Project #: 1001386

Project Name: CORONA DEL SOL SUBDIVISION

Re: DRB Sign Off of City Project Number 1001386, 13EPC-40154: Desert Hills Site  
Development Plan for Building Permit

Project# 1001386  
13EPC-40154 Site Development Plan for Building  
Permit

C1.1

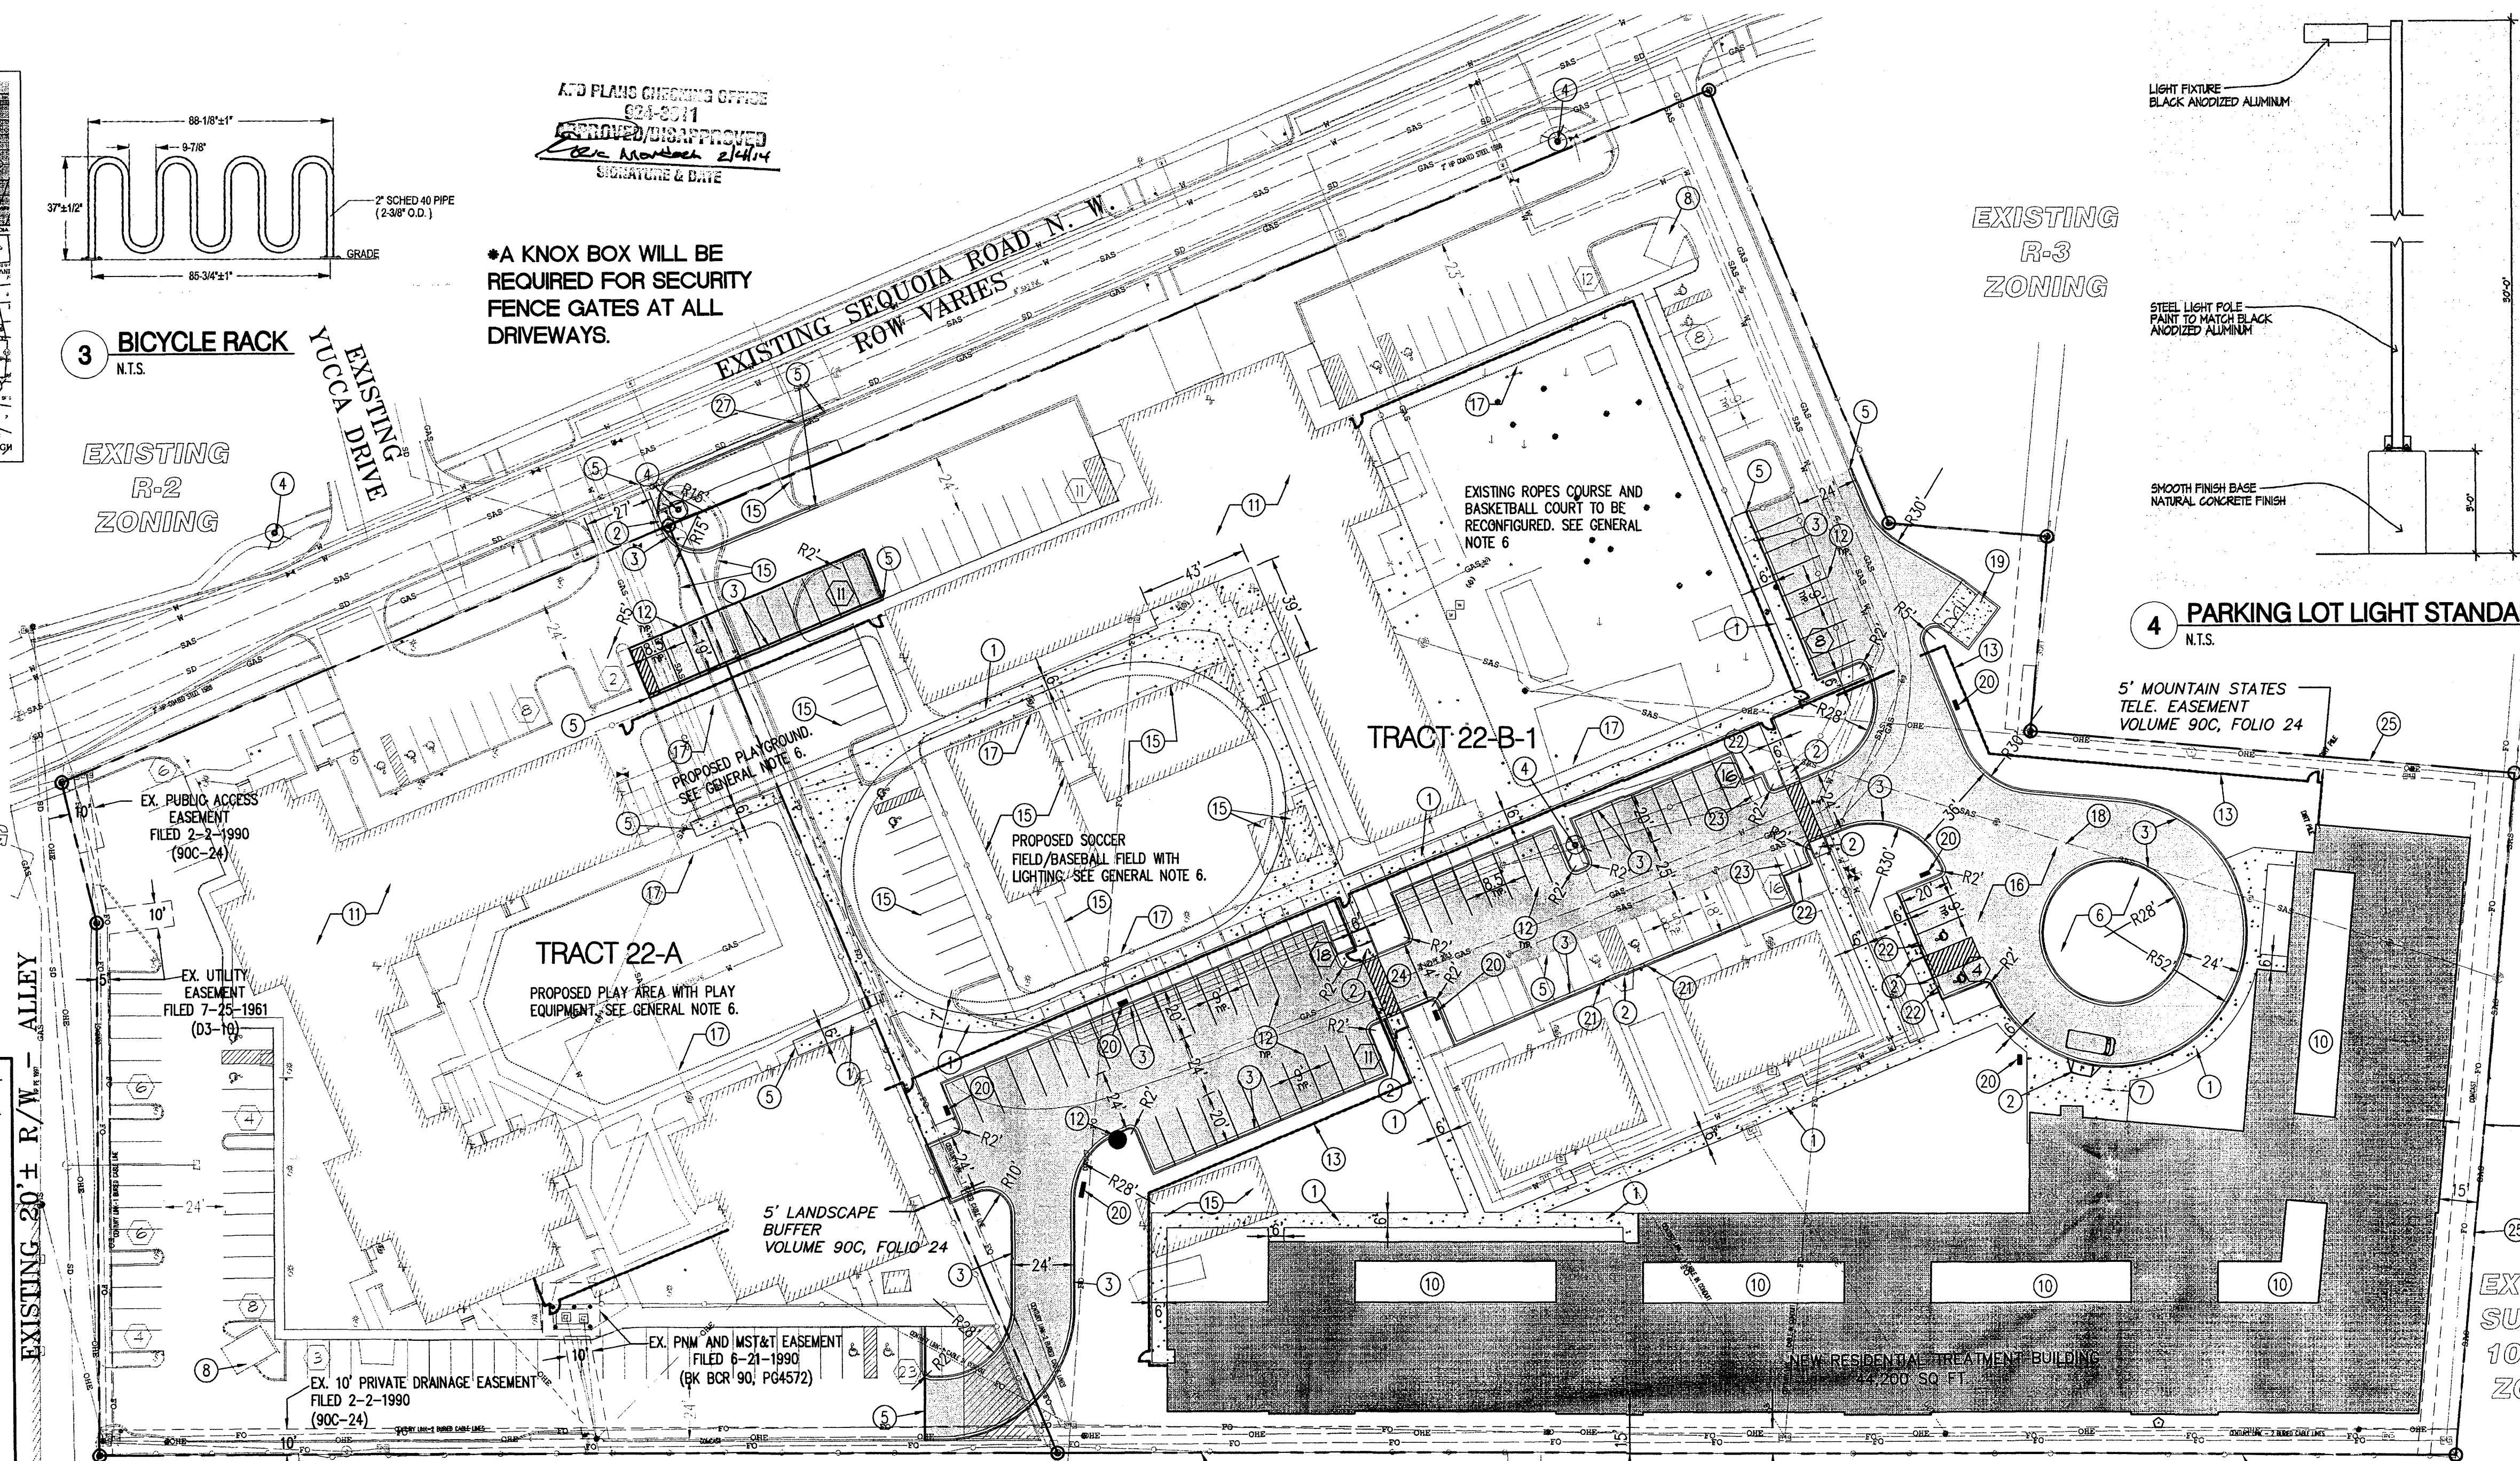
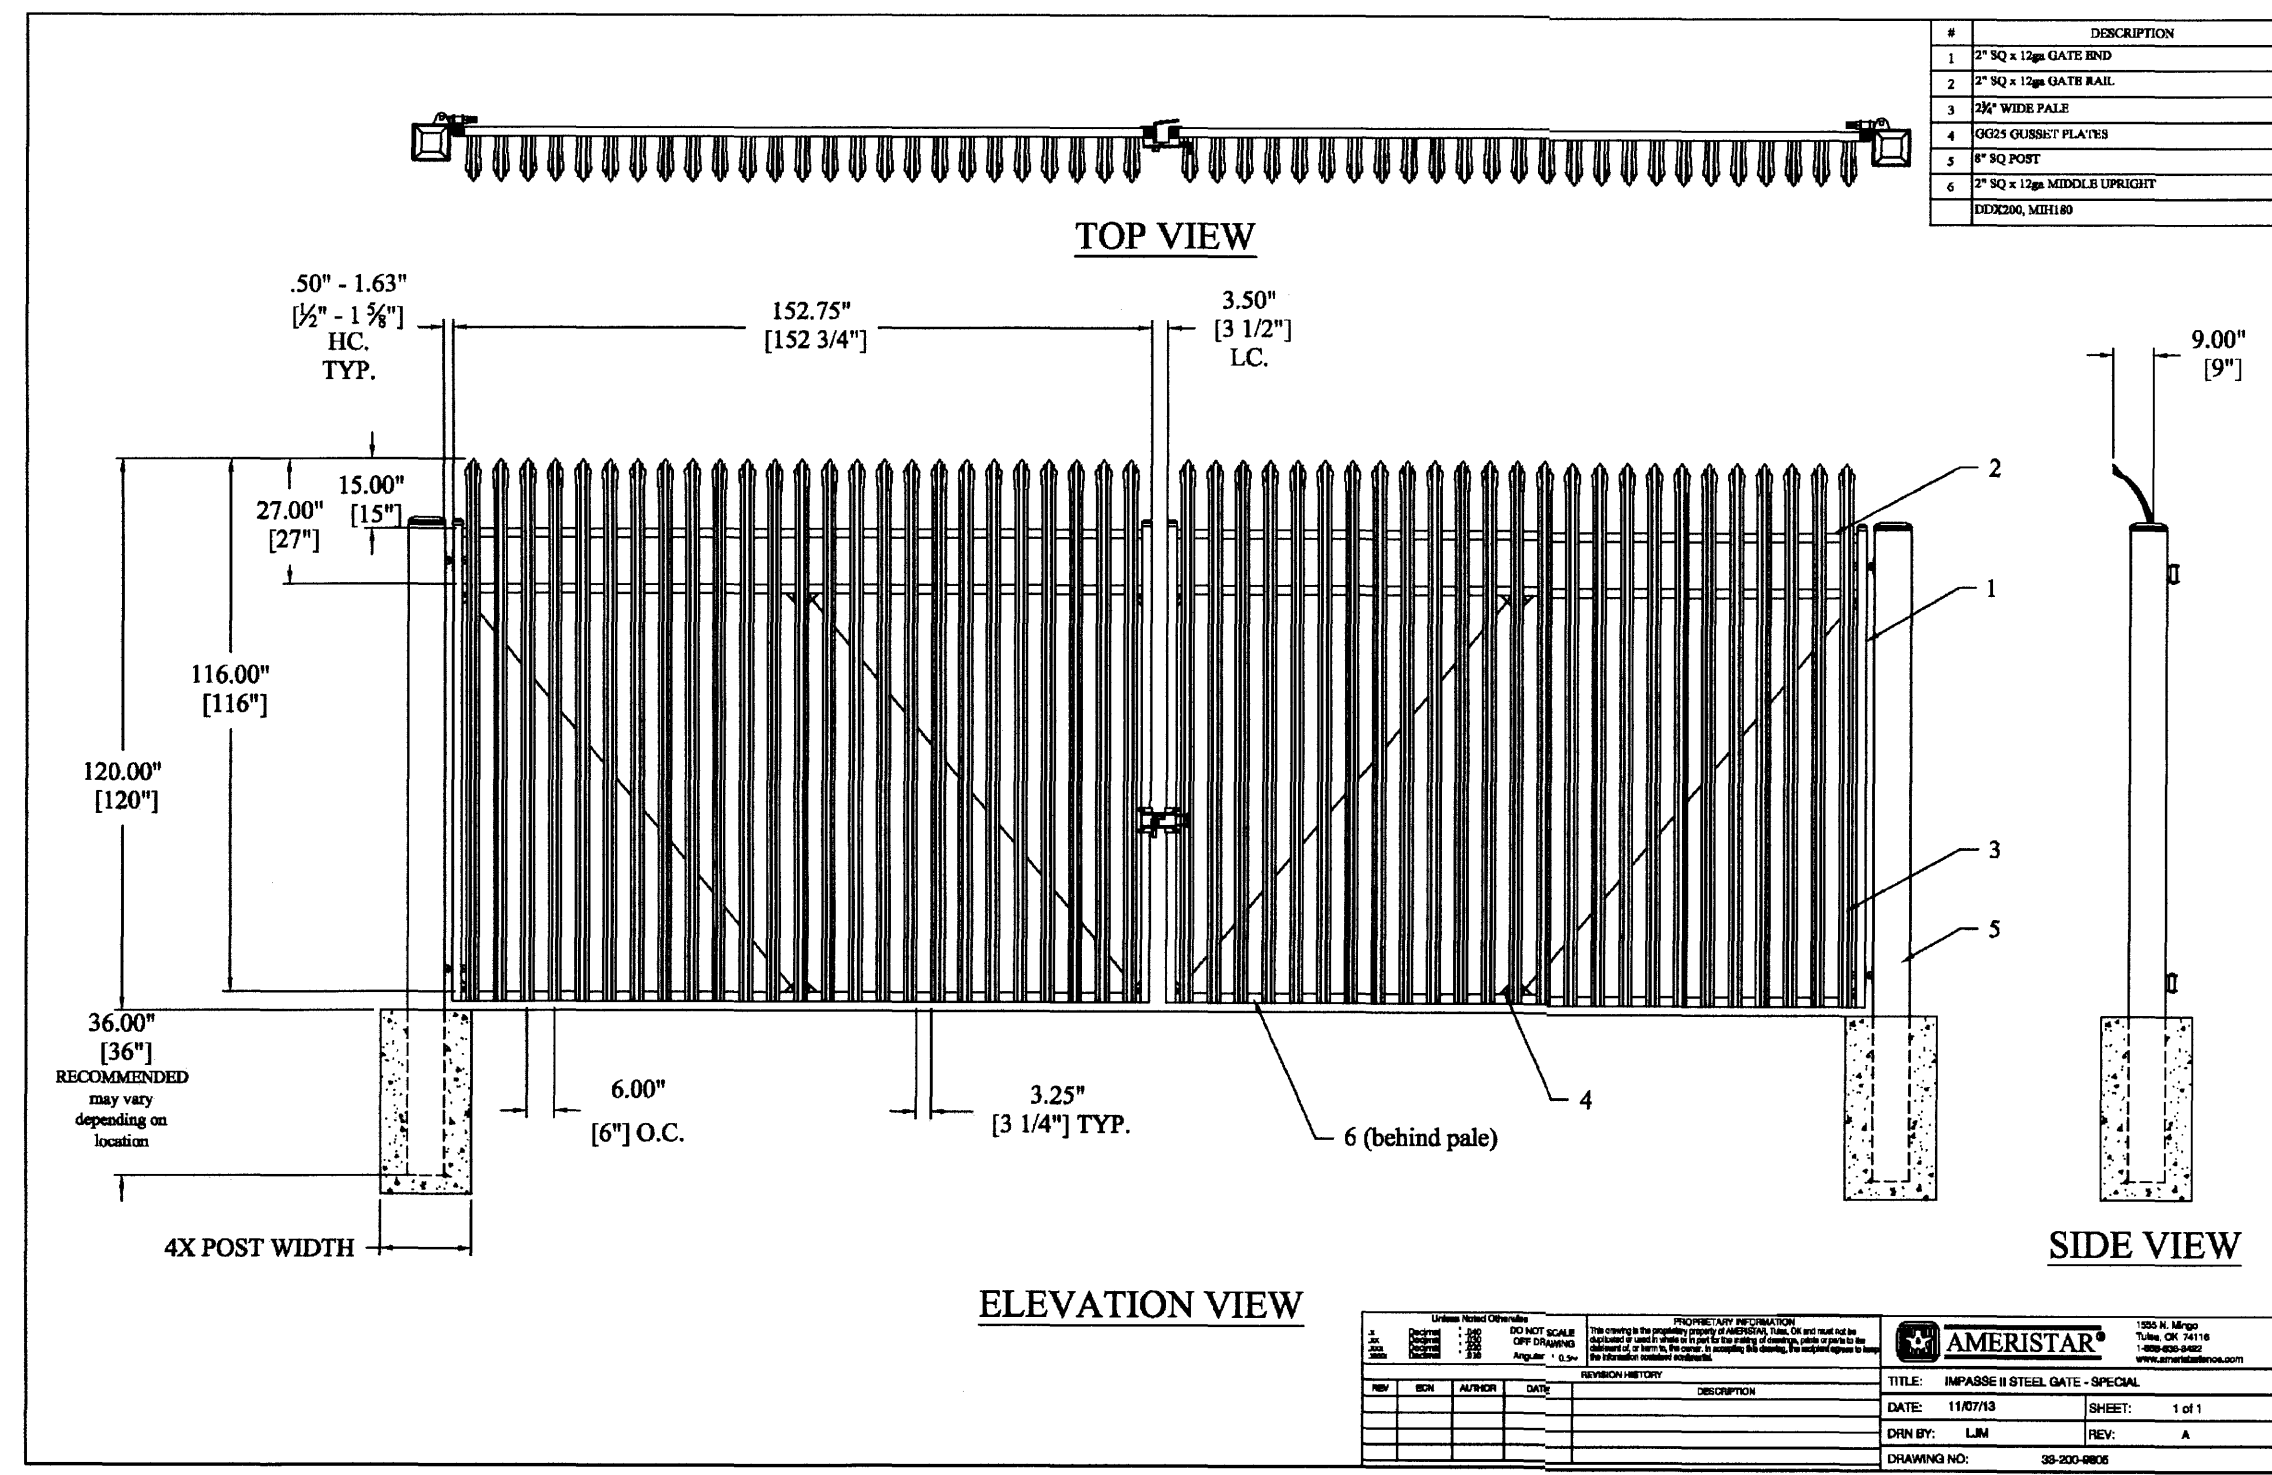
6. All requirements of previous actions taken by the EPC and/or DRB have been completed and are included as a part of this submittal.
7. Details of the perimeter fence are provided on the Site Development Plan for Building Permit Sheet C 1.1A.

8. General Note *number 7* has been added to Sheet C1.1 and General Note number 5 has been added to Sheet L1.1 as required by this condition.
9. A draft Cross Access agreement/easement between Tracts 22-A and Tract 22-B-1 is being prepared. This agreement will be filed prior to DRB final sign-off.
